Limmer Lane House  
122a Limmer Lane  
Felpham PO22 7LR

**Planning Application no. FP/212/20/OUT at 6 The Loop PO22 7ND**

Sunken garden view north

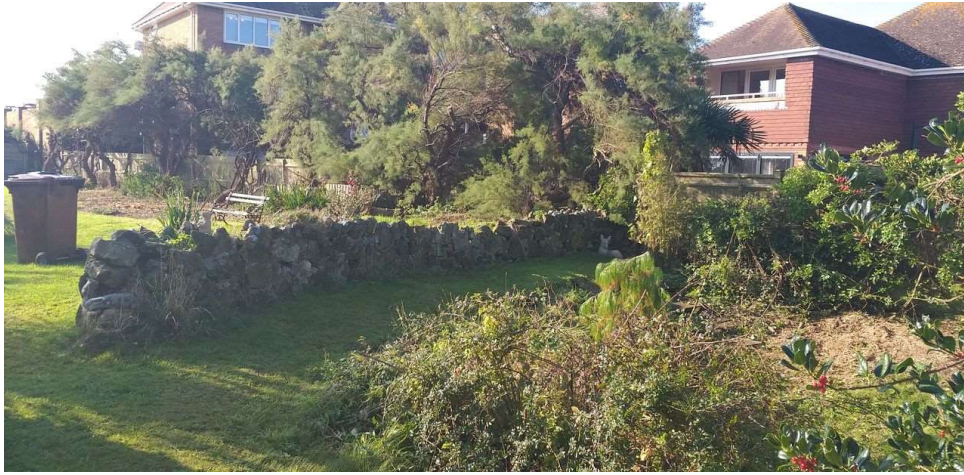
Number 6 The Loop plays a crucial role in the drainage system in that the gardens contain an ancient drainage pond and pipes which connect to the main sea outlet pipe running down Jacken Close. I note that the planning application describes this drainage pond as “the sunken garden” which might be an error or could be an attempt to mislead.
